# Rezoning Transportation Analysis

Petition Number: 2020-019

Revision Log:	Date	Description
	03-25-2020	First Review
	4/20/20	Second Review

The Plaza Road Townhomes site is located on Plaza Road (minor thoroughfare, State maintained) and is outside of Route 4. The site is within the limits of the Eastside Strategy Plan Study Area.

RZ-1

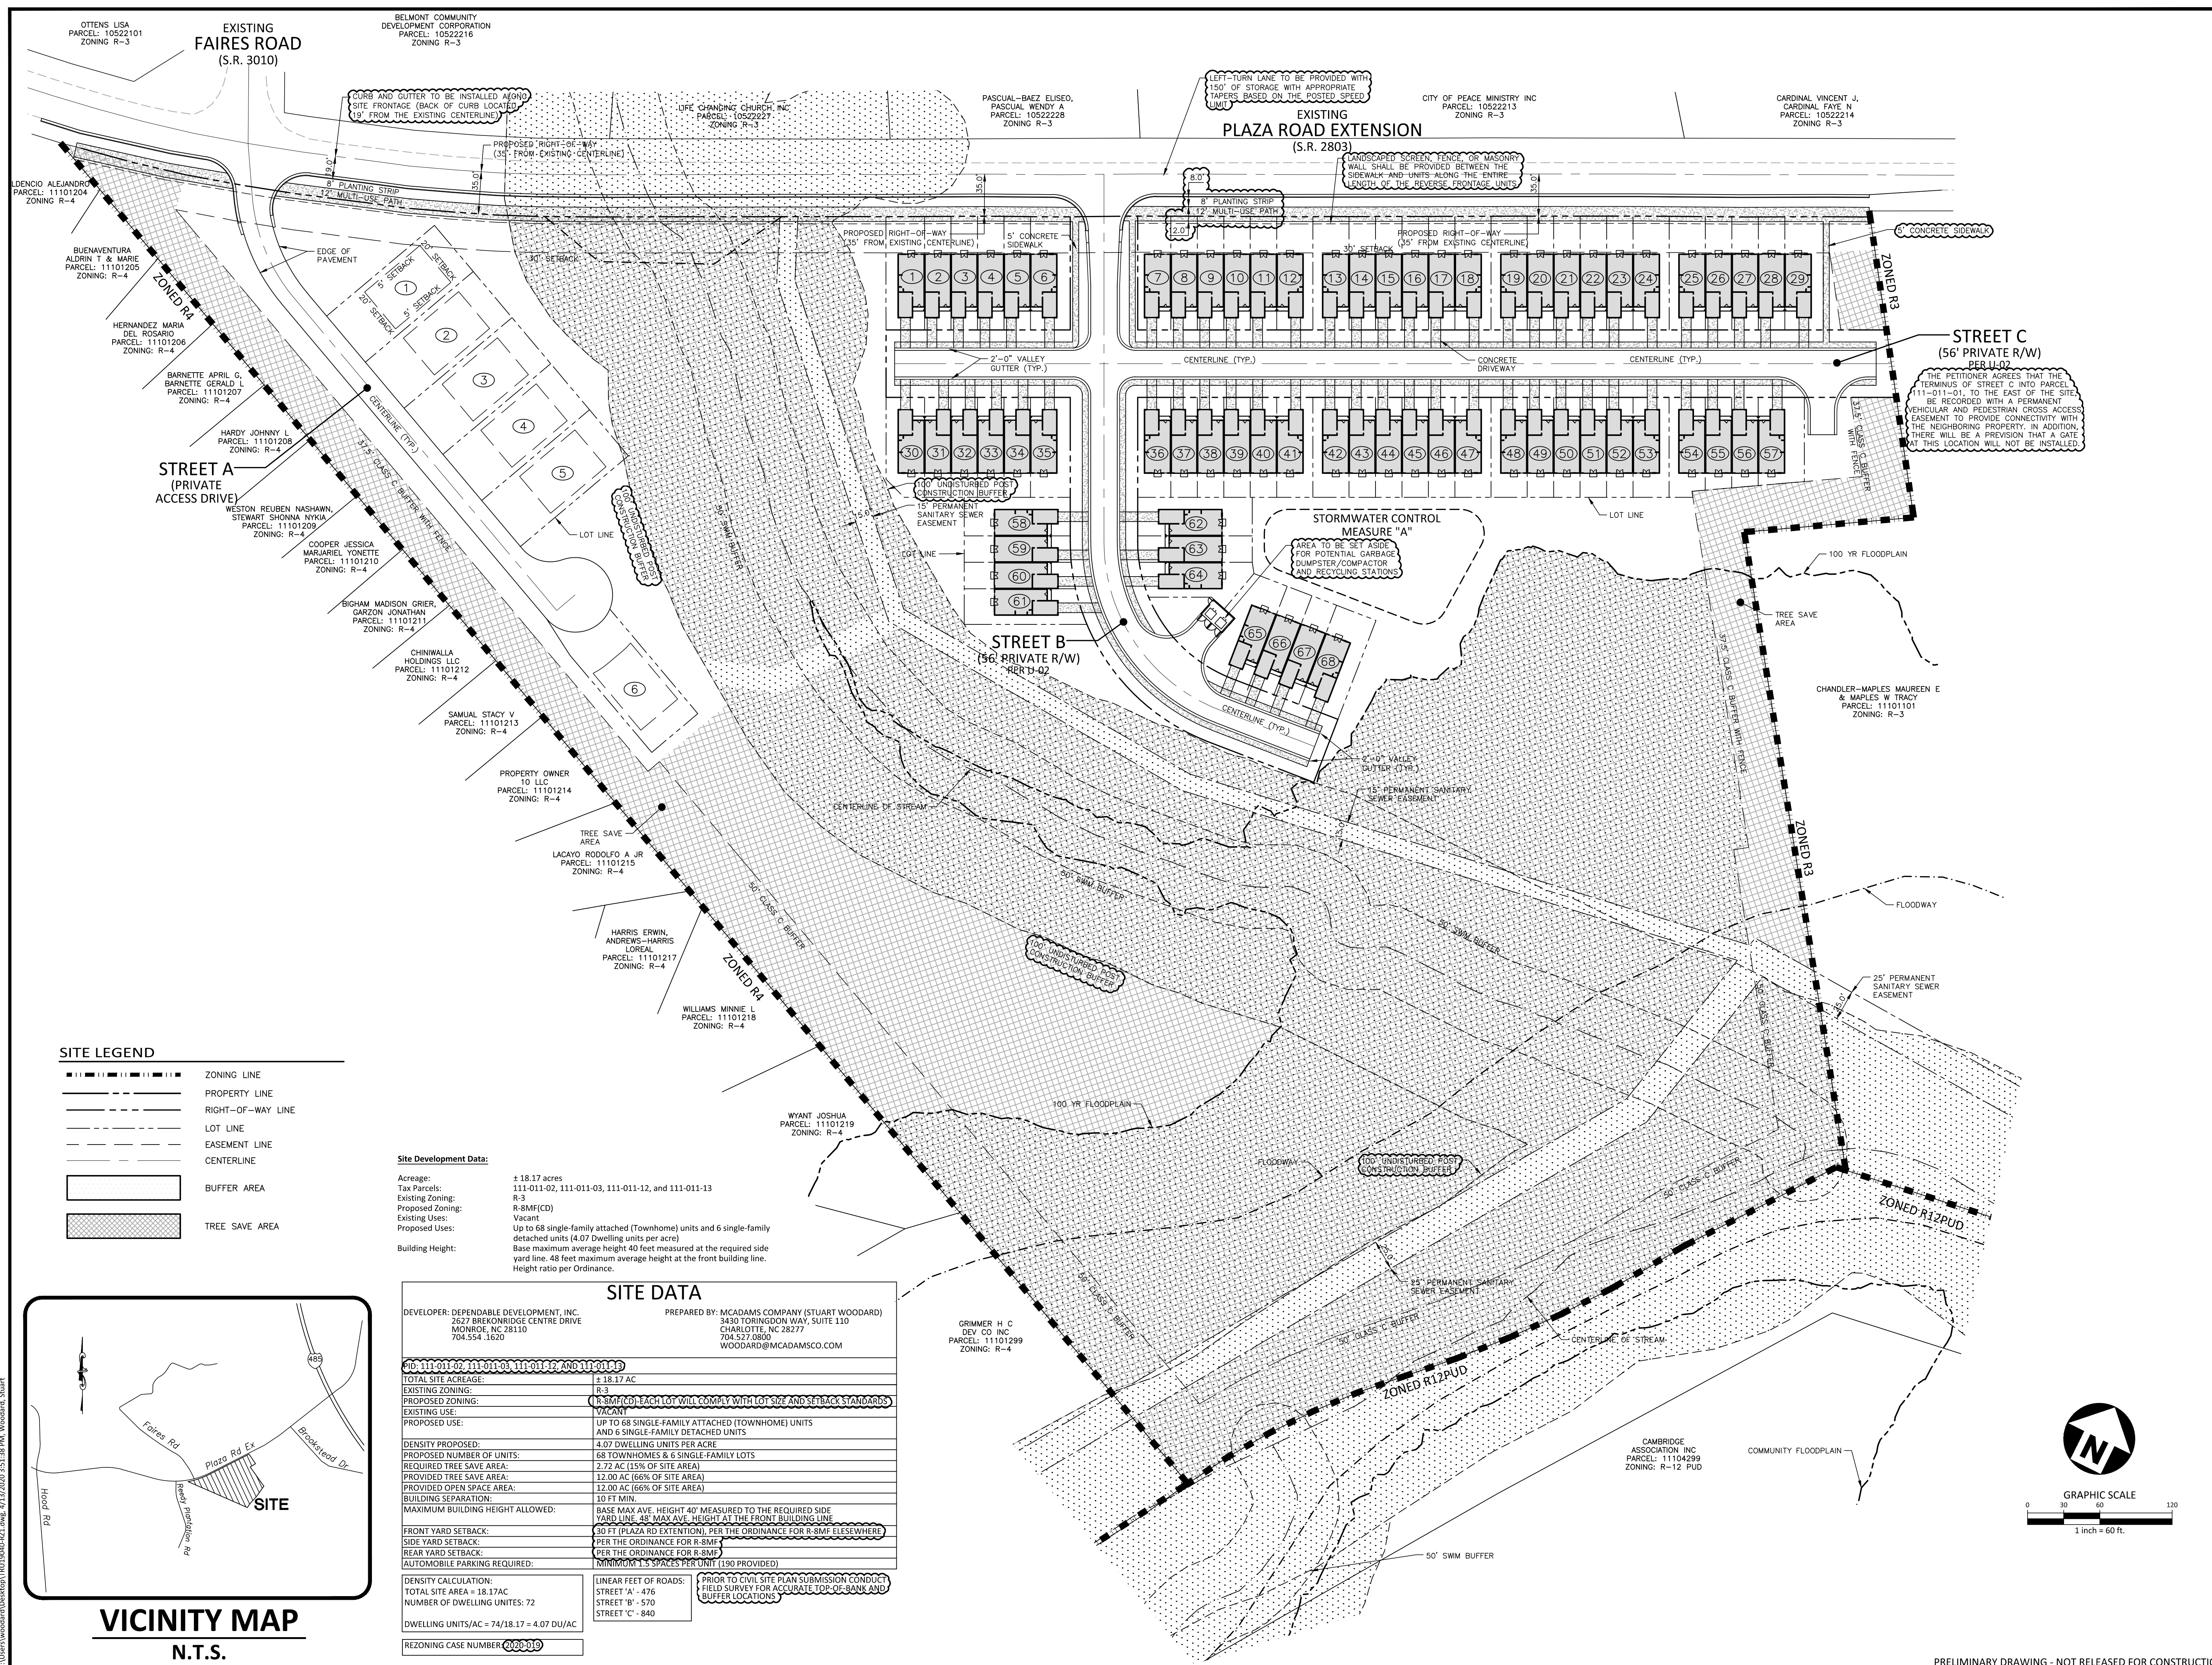
5. ~~The petitioner should revise the site plan and conditional note(s) to commit to construct a 3-lane section along The Plaza.~~
6. The petitioner should revise the site plan and conditional note(s) to commit to construct an 8-foot planting strip, and 5-foot sidewalk on all the Private Streets. The site plan should label and dimension both items

7. The petitioner should revise the site plan and conditional note(s) to commit to construct an 8-foot planting strip, and 6-foot sidewalk on Street C. The site plan should label and dimension both items.
